TECHNICAL NOTE

Job Name: SGR1 Land
Job No: 41436/2002
Note No: TN003
Date: 12/10/18
Prepared By: APLR
Subject: **PBA response to CDC planning consultation comments**

This Technical Note has been produced by PBA to respond to the comments provided by Cherwell District Council, in respect to the outline planning application for the development known as the SGR1 Land.

**LAND TO THE WEST OF HOME FARM,
 BICESTER
 PROPOSED SURFACE WATER DRAINAGE
 STRATEGY**

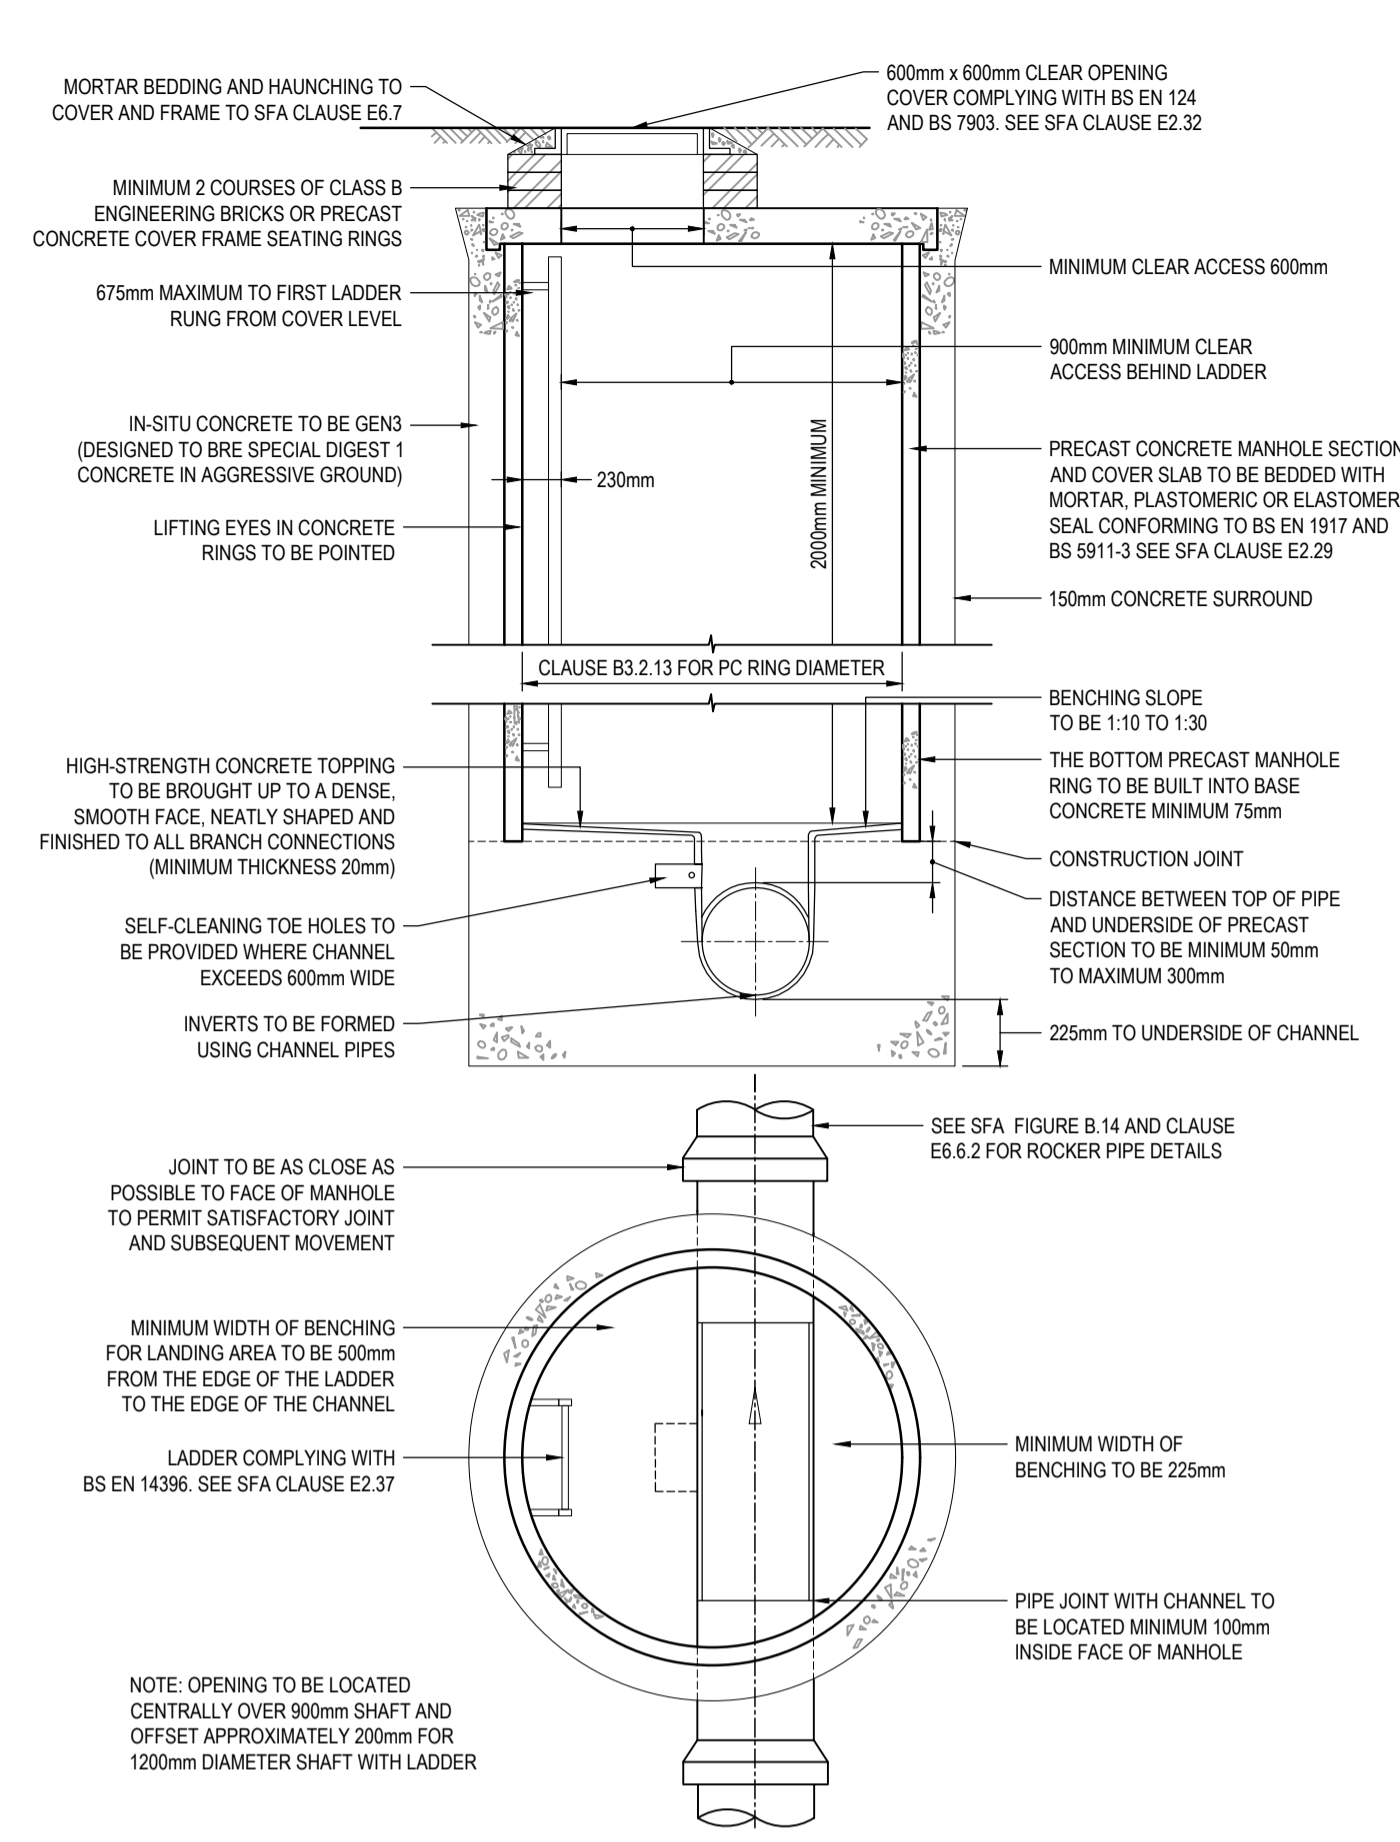
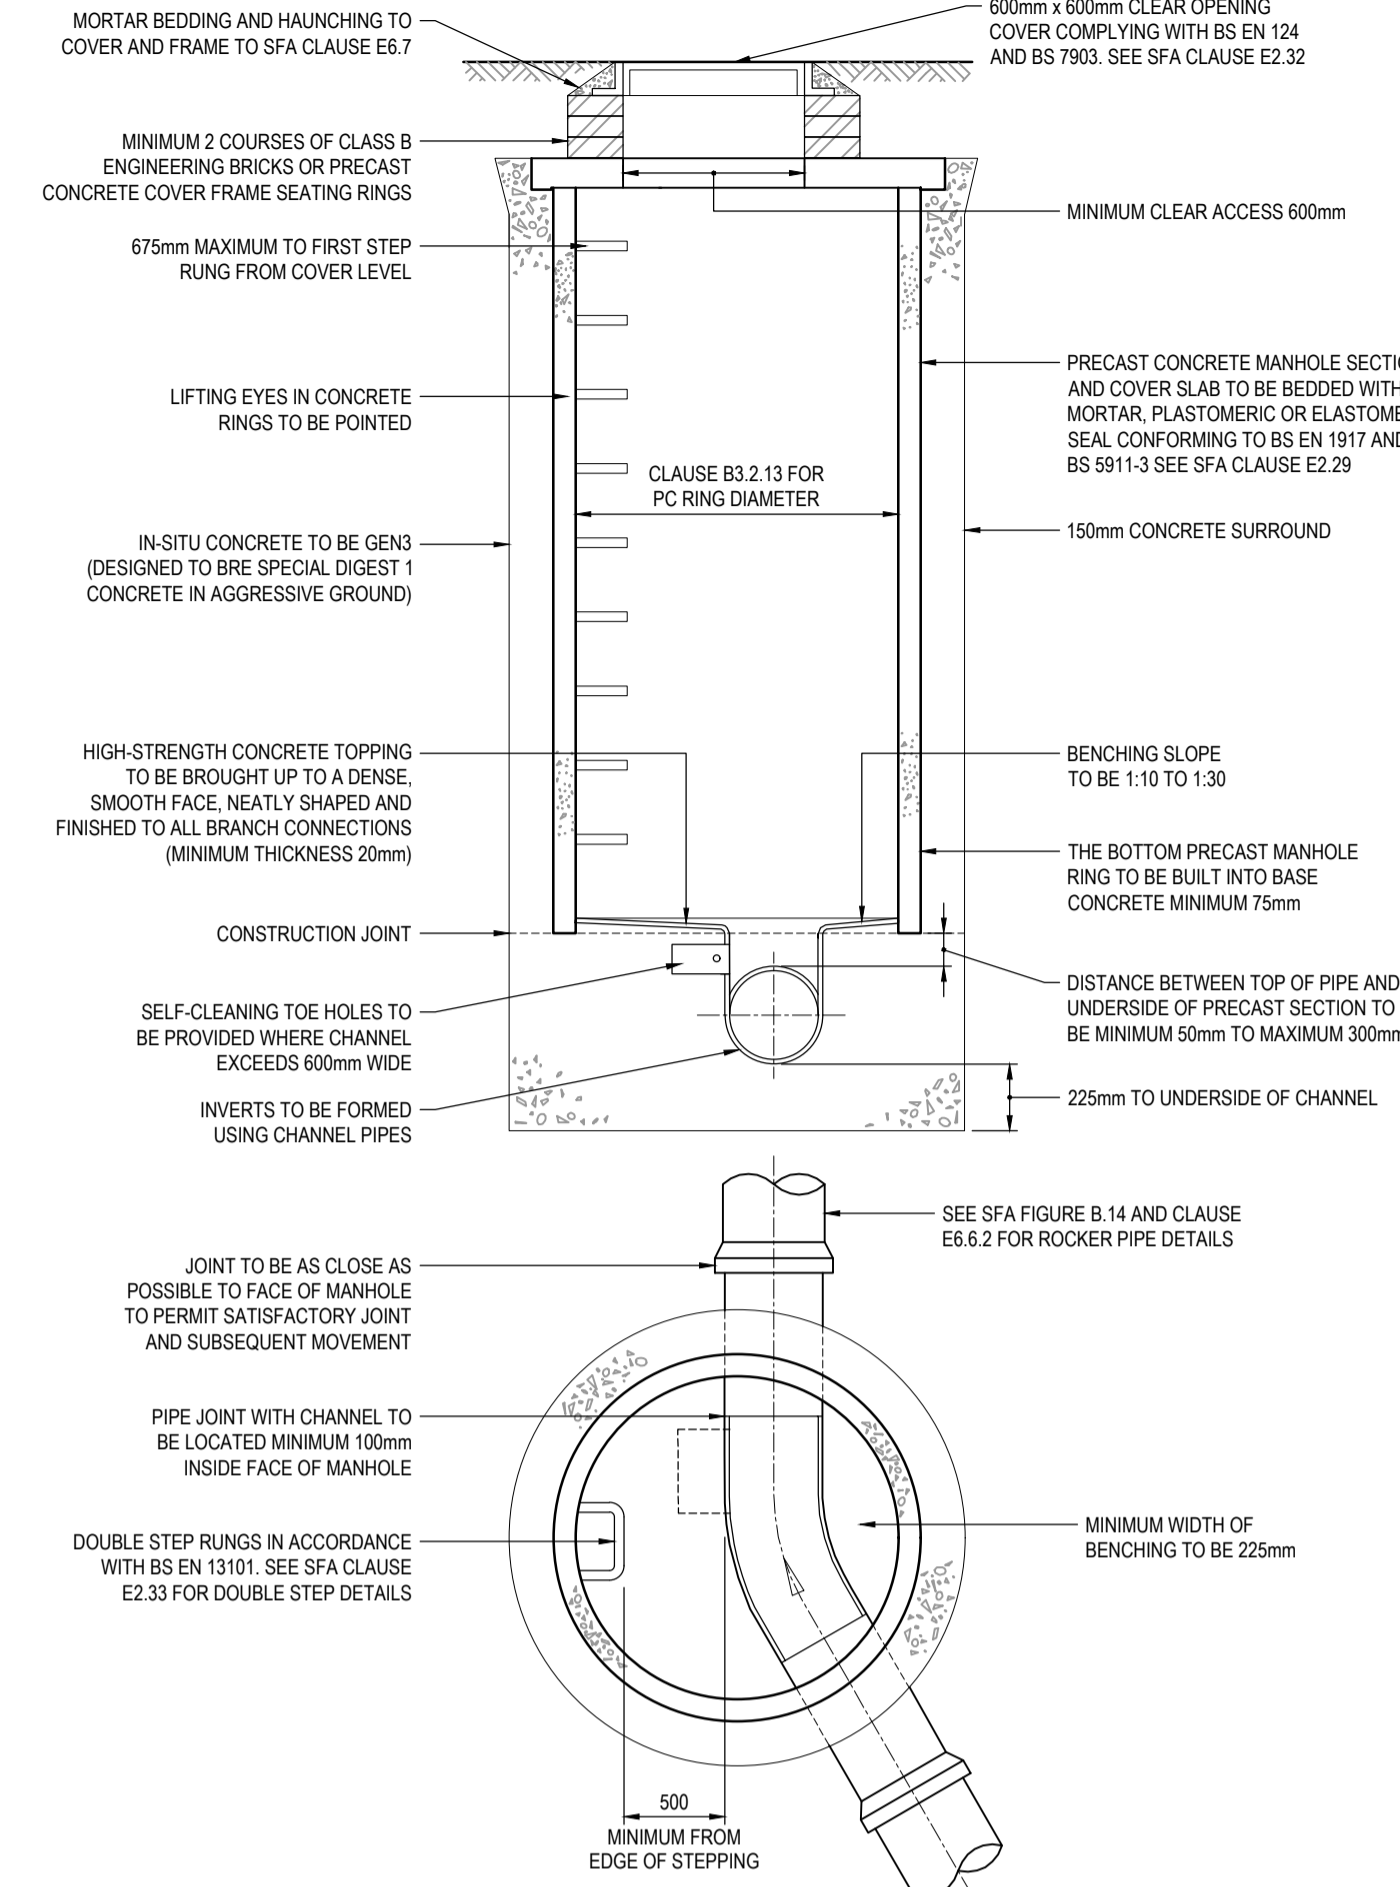
The Landscape Officer has commented upon the engineered balancing pond which is seen as an unnatural feature in the landscape setting. Whilst I am aware this is not for approval at this stage, I would agree that any SUDs features will be required to be properly designed so as to be a natural feature, provide interest and amenity and be safe within an area of open space.

We have reviewed the EA and Cherwell District Council planning comments and think that the only way to overcome them is for the client to agree to accept planning conditions committing to the following.

- The use of rainwater harvesting
- Undertake a detailed assessment of the site's ability to utilise infiltration drainage techniques as part of the geotechnical investigation at the detailed design stage, and
- If following completion of the detailed geotechnical investigation the detention basin is still required, develop a detention basin layout and planting scheme that naturalises its appearance and enhances the detention basins water quality and amenity benefits.
